Your Ref: OWPC14630
Our Ref: BR/194/17/PL 30-06-2017
Please ask for:
Richard Temple

Demolition of the existing Foreshore office & decommissioning of existing underground toilets. New purpose built unisex toilet block including urinals, baby changing facilities & accessible WC, plus a separate beach office with public information point & first aid facilities. All located on the existing seafront promenade.

Promenade Opposite Clarence Road The Esplanade Bognor Regis

DRAWING
Proposed Toilet Elevations

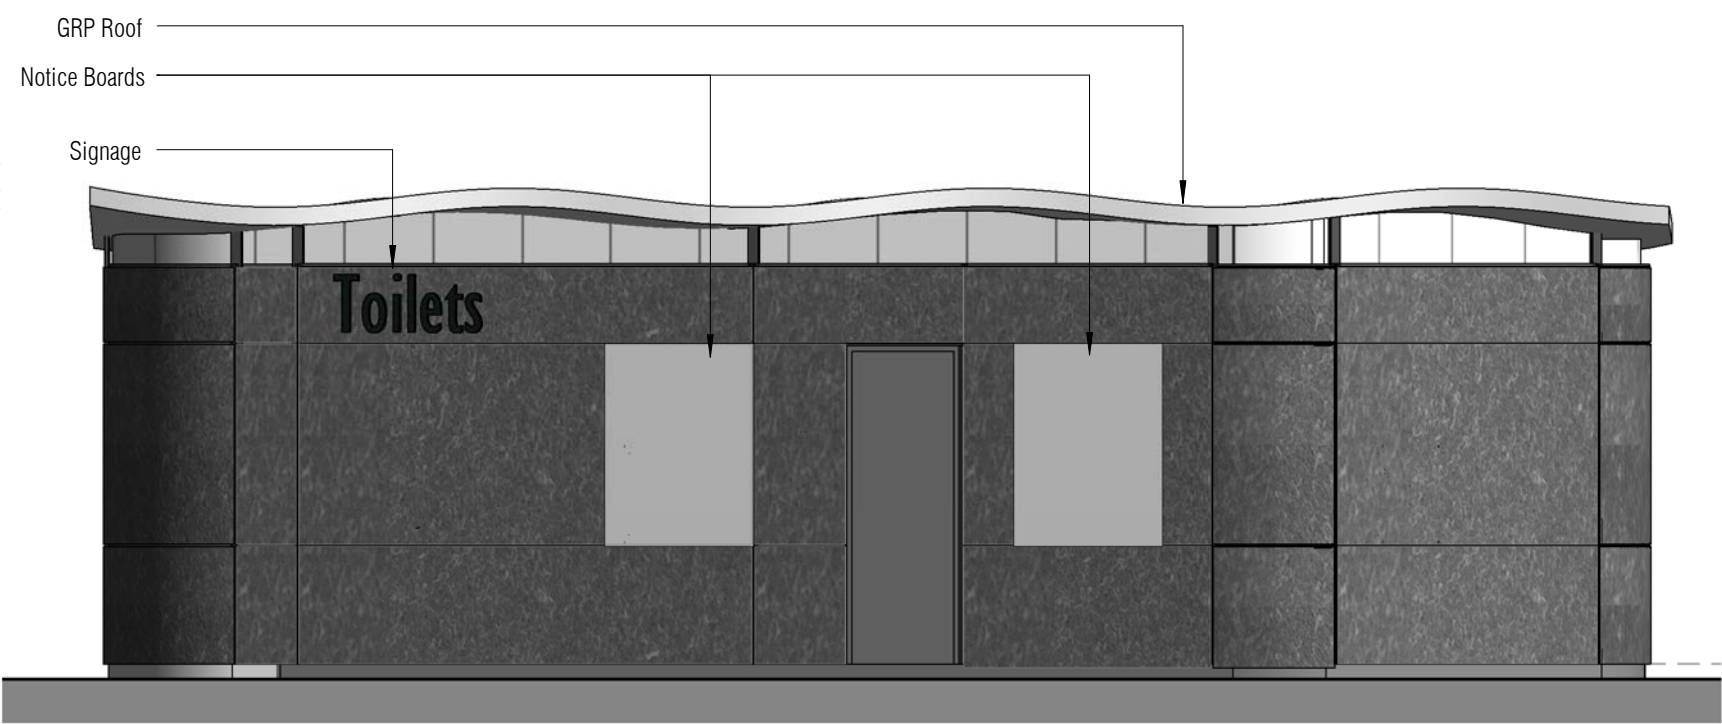
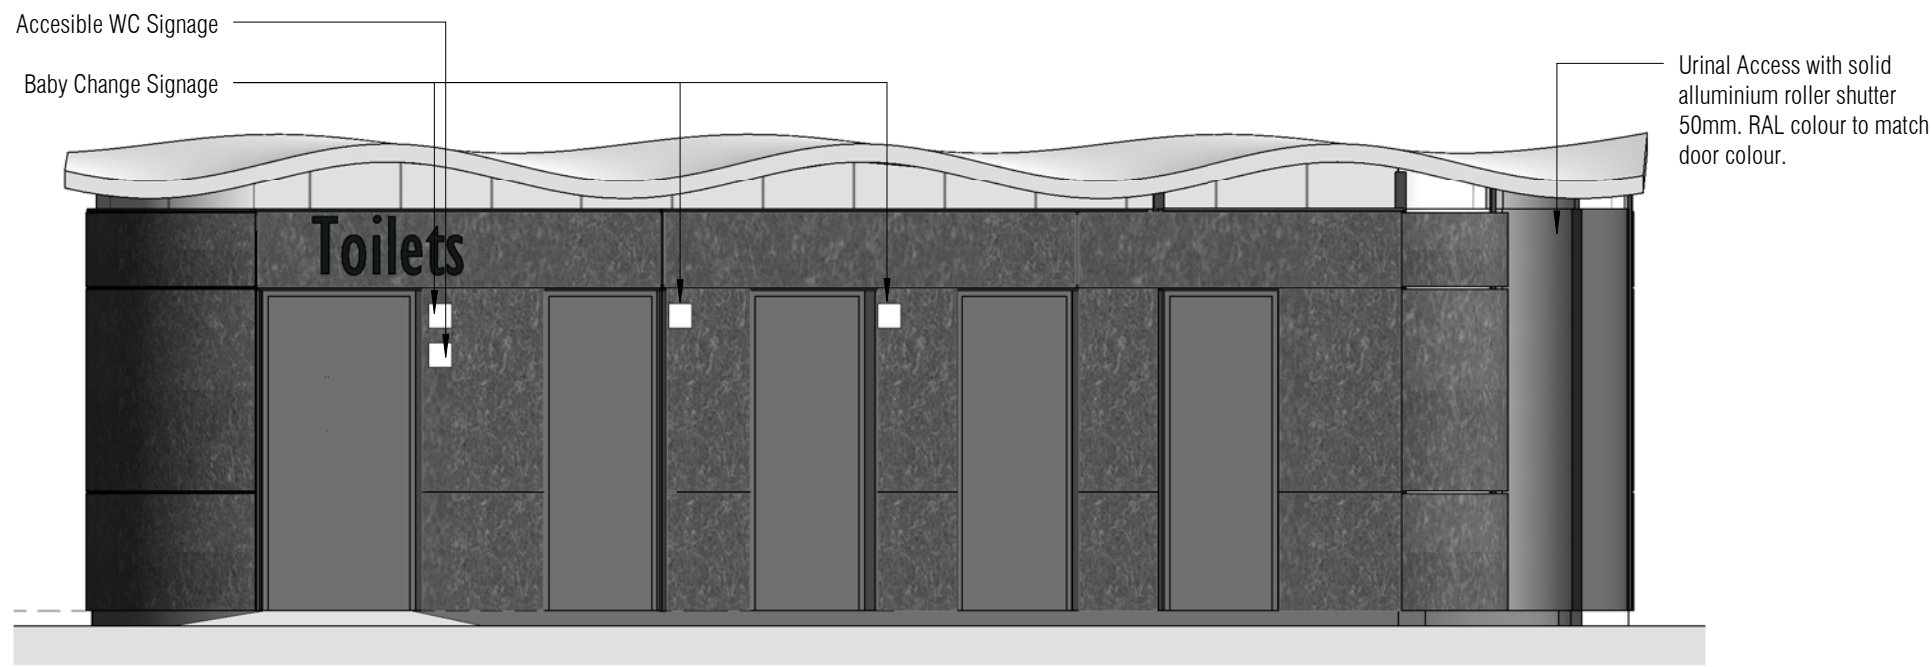
Now the weather for all the reasons Arun DC give for the North Facing Entrance doors This is NOT as correct as Arun belive, Bognor Regis has some 30 days of South West Winds in Excess of force 7 and of course the Esplanade is awash with people on those days? (I don't think so) common Sence says the doors must be South Facing and Not in Full view of the Many Residents who will be faced with Jo Public arranging their dress after having used the Loos for what ever reason?

Bognor with the the rest of the south coast east of the IOW now have more Easterly winds and with the doors hung the correct way the Wind will help in their CLOSURE, and make for a perfect solution.
